REF: 22/01144/F

Location: OS Parcel 5700 South West Of Grange Farm

Holding objection

25 May 2022

Detailed Landscape Proposals

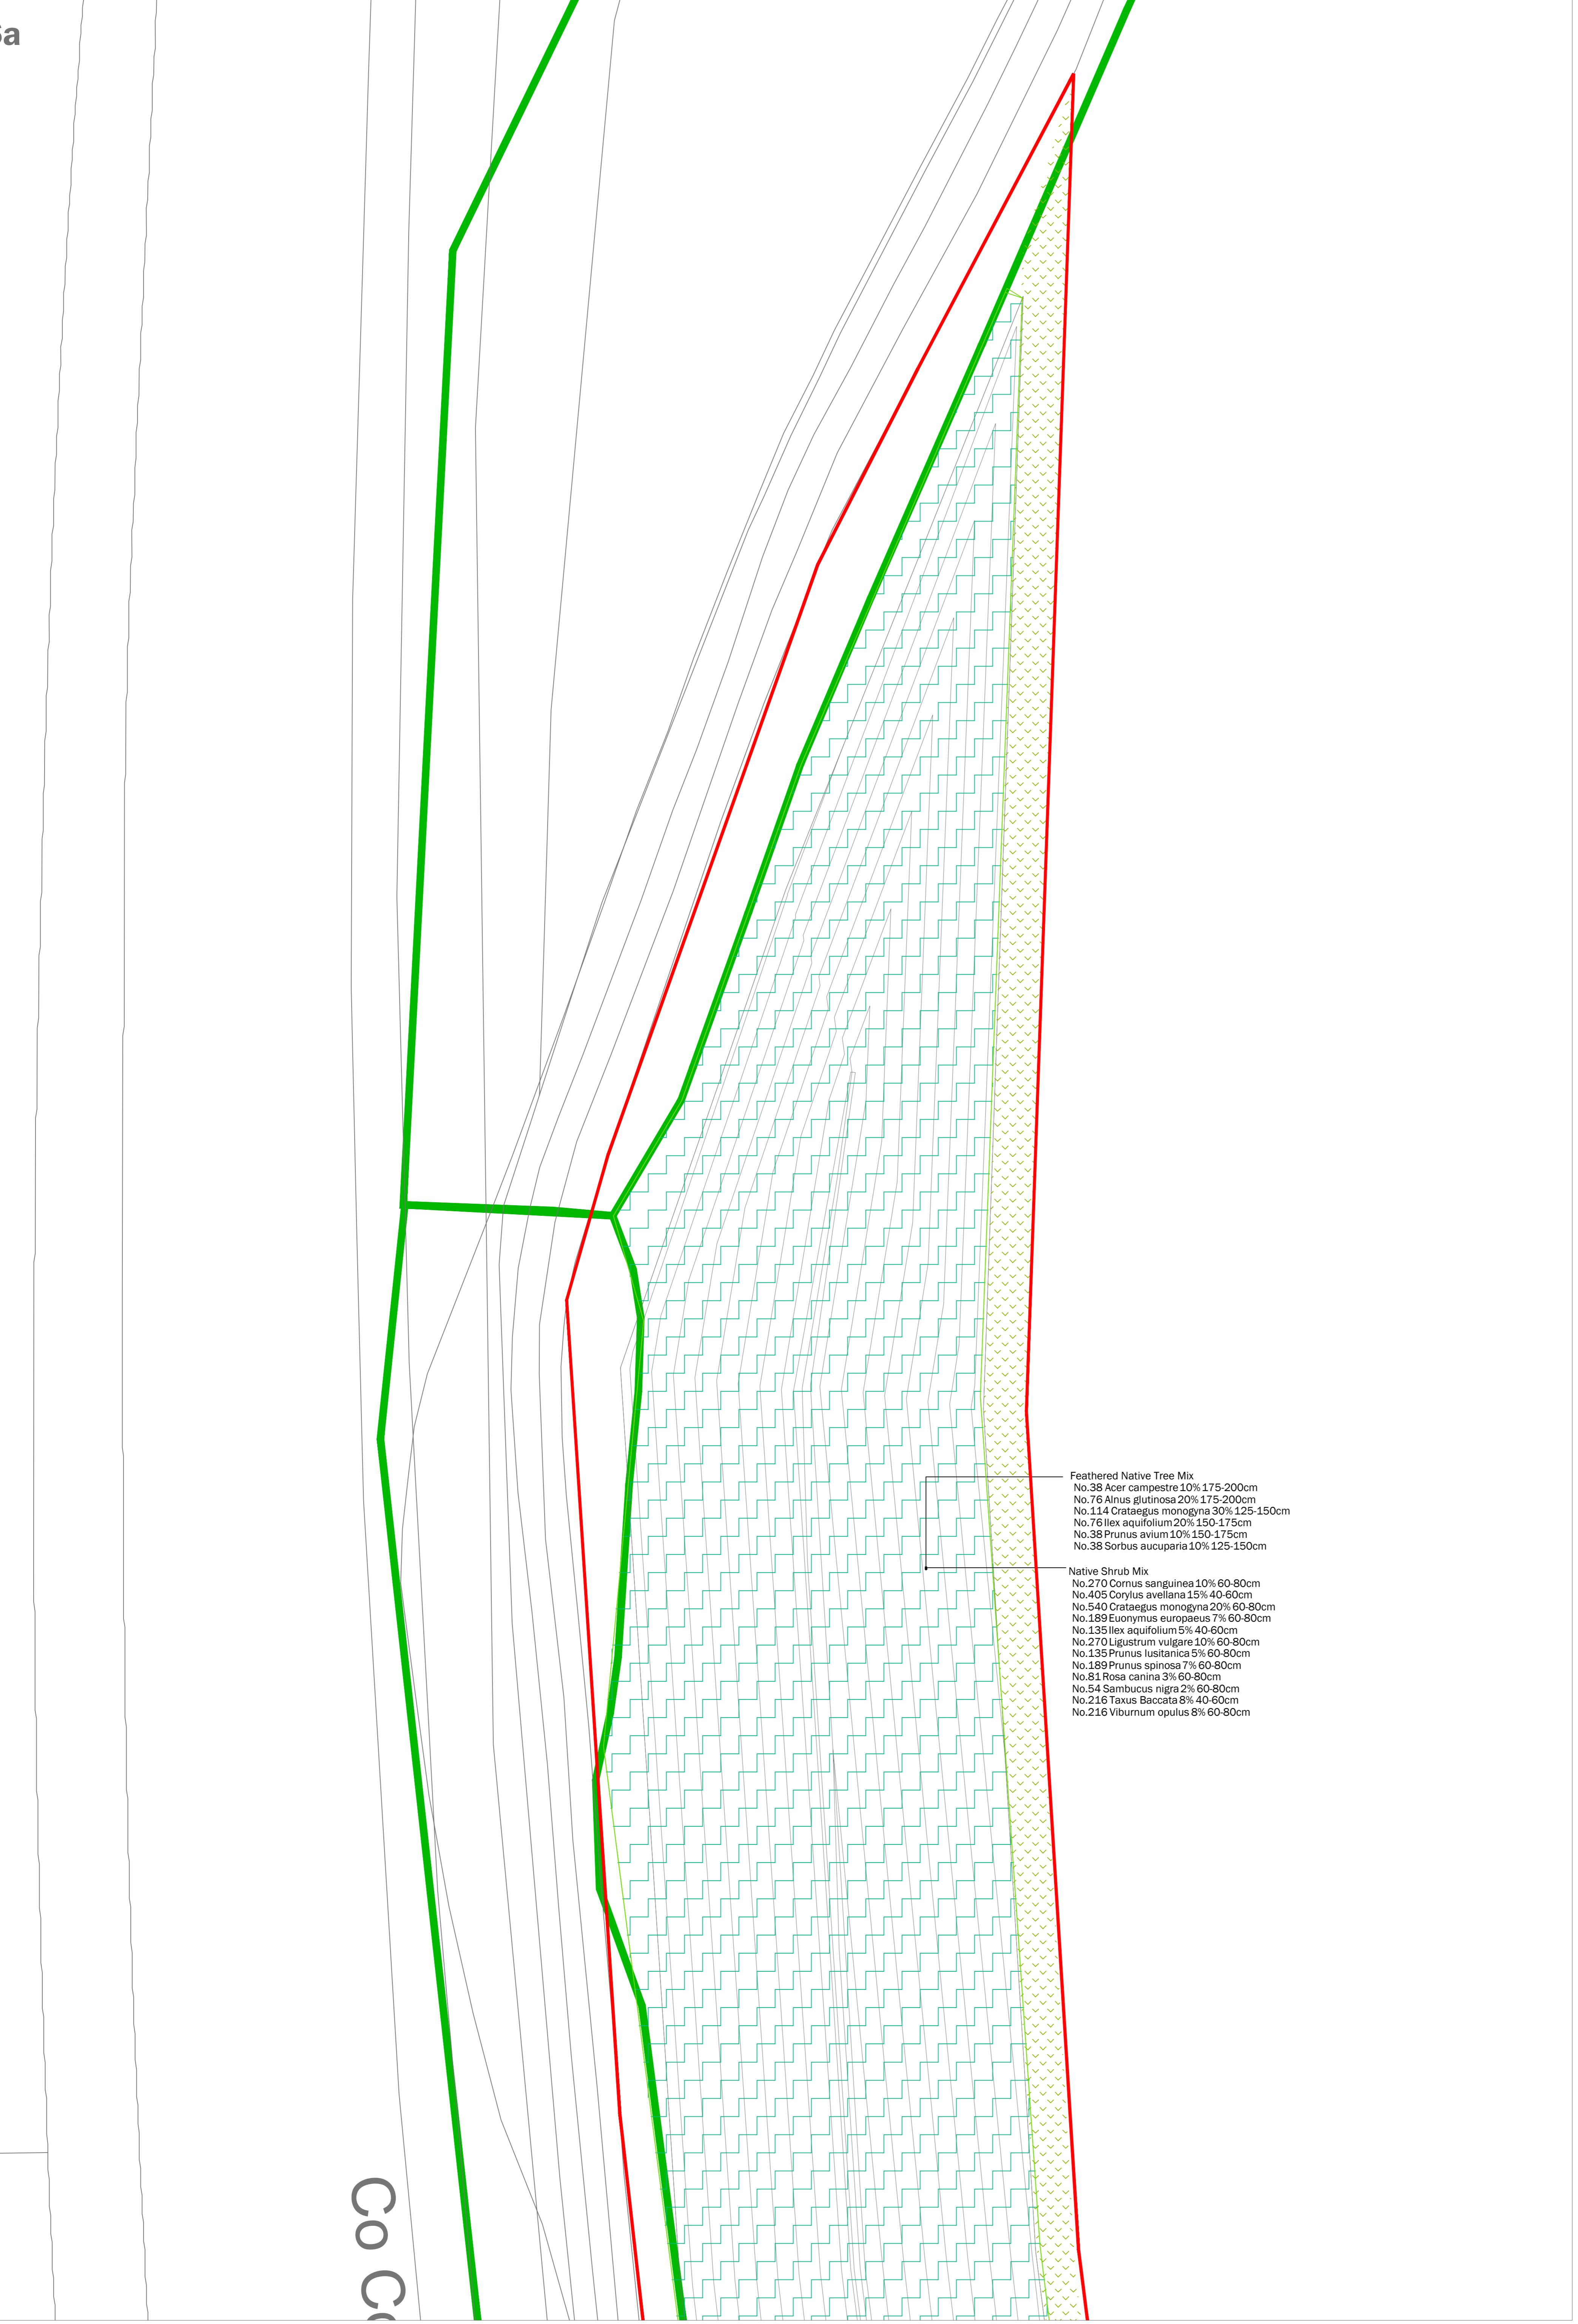
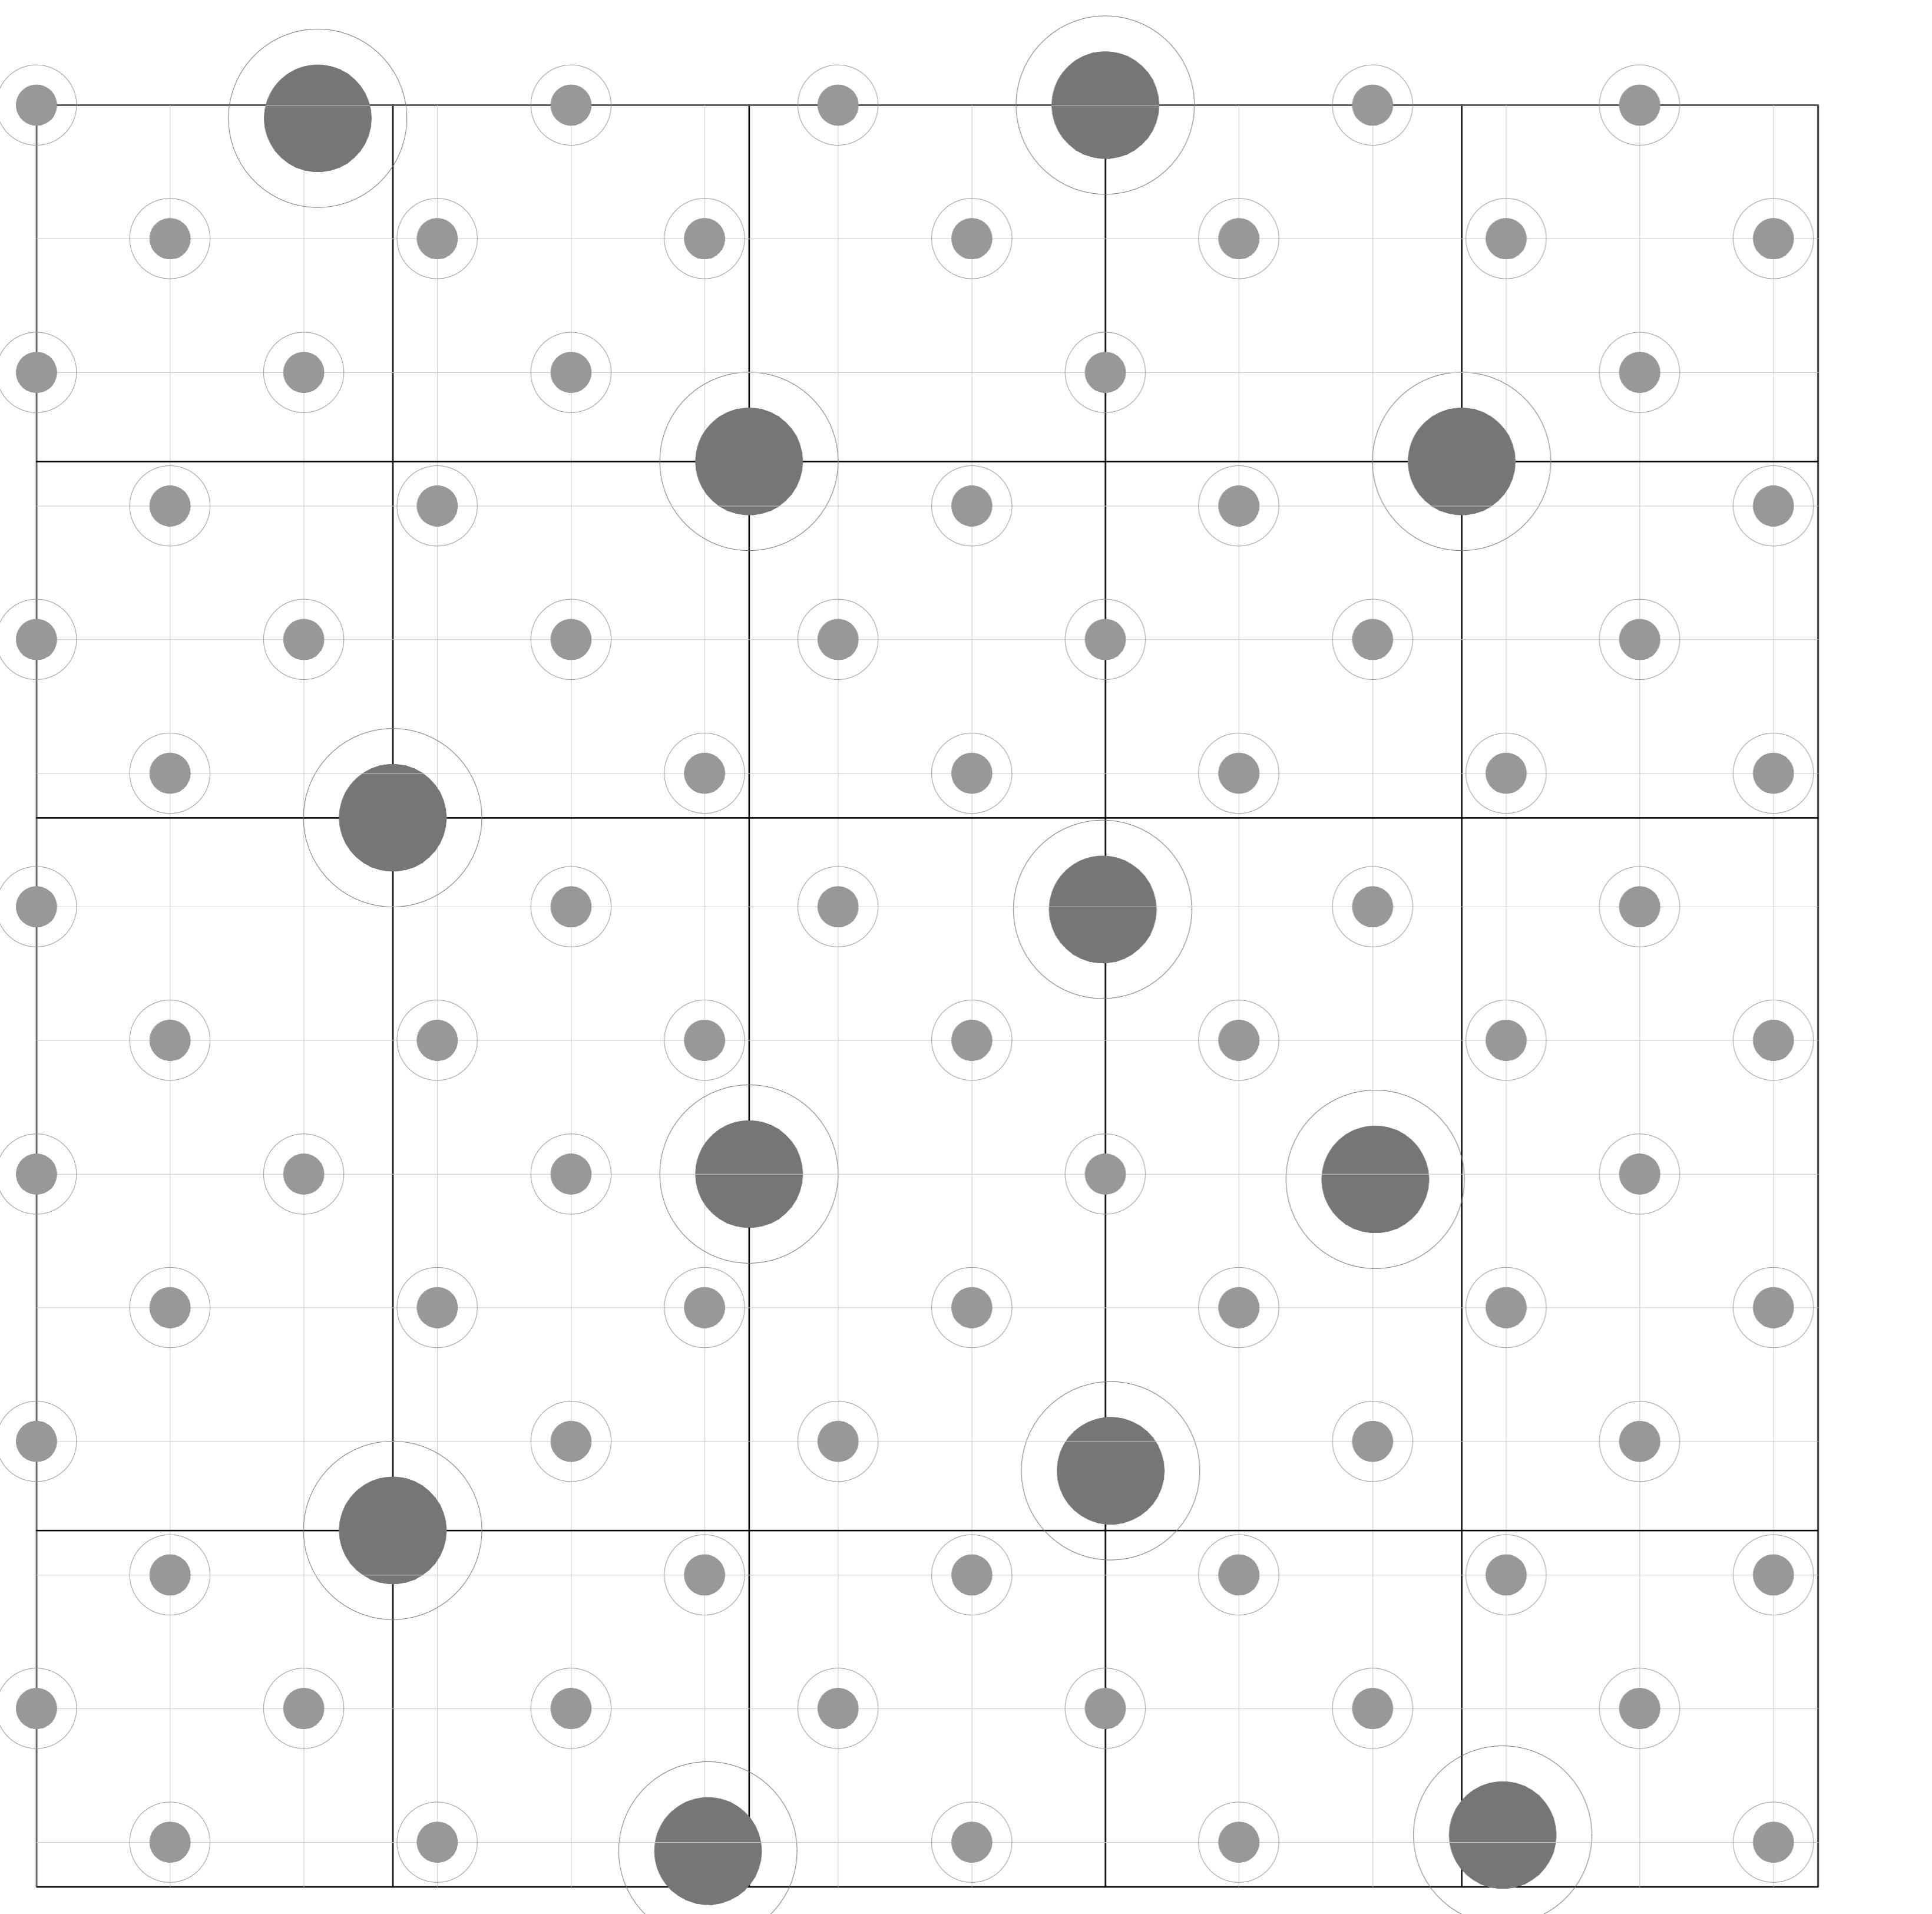
- Landscaping plans indicate it may also be possible to access the car park and surrounding areas via vehicle, as suitable vehicle mitigation measures do not appear to be present. There have been incidents of illegal encampments within the surrounding area over the last 24 months.
